Item No. **Report of the Head of Planning, Transportation and Regeneration**

Address 88 VINE LANE HILLINGDON

Development: Two storey rear extension, refurbishment works, installation of dormer to front and alterations to elevations

LBH Ref Nos: **39894/APP/2020/346**

Figure 07: Width of proposal sits within extents of existing dormers

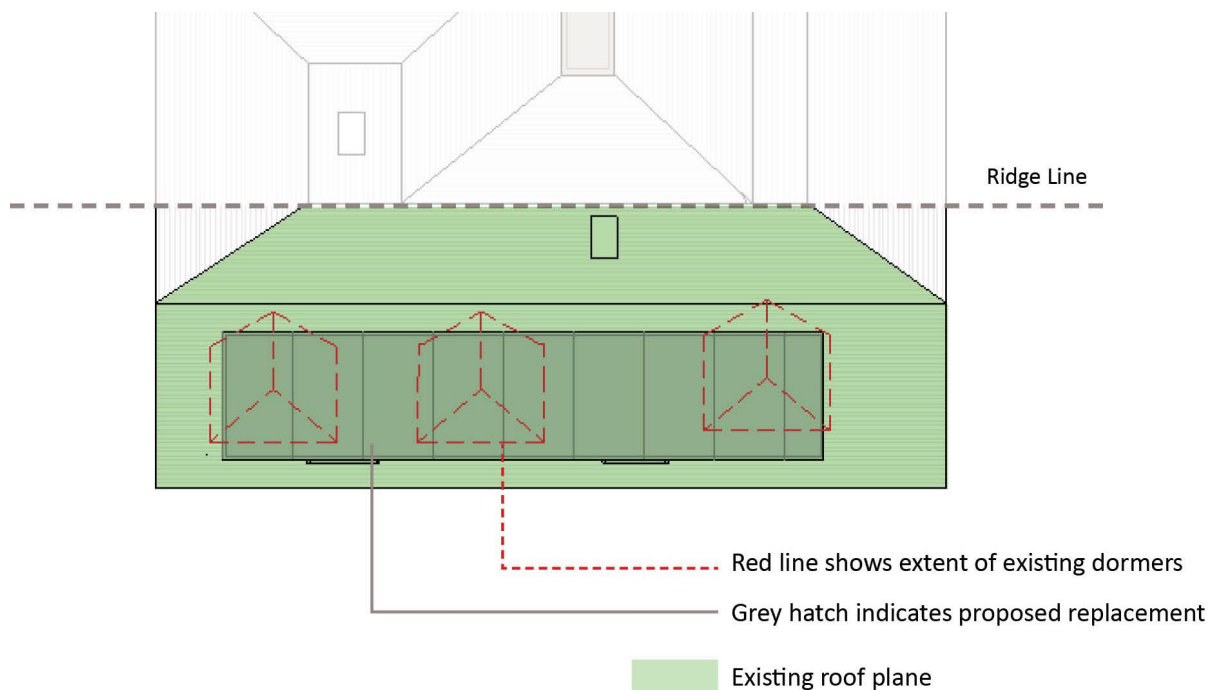
The existing house has three pitched roof dormer windows. The applicant proposes to replace this with one dormer window with flat roof across the width of the front roof. The proposed dormer window, by reason of its size, width, design and position on the front roof slope would result in a bulky development that would not form a traditional dormer window. Therefore, the development would be contrary to Policies DMHD 1 and DMHB 5 of the Hillingdon Local Plan: Part Two - Development Management Policies (2020).

The proposed front dormer window, by virtue of its siting, size, scale, width and design would fail to appear as a subordinate addition and would thus fail to harmonise with the architectural composition of the original dwelling, would be detrimental to the character, appearance and visual amenities of the street scene and the surrounding Hillingdon Court Park Area of Special Local Character. The proposal is therefore contrary to Policies BE1 and HE1 of the Hillingdon Local Plan: Part One - Strategic Policies (November 2012), Policies DMHB 1, DMHB 5, DMHB 11 and DMHD 1 of the Hillingdon Local Plan: Part Two - Development Management Policies (2020), Policy 7.8 of the London Plan (2016) and the NPPF.
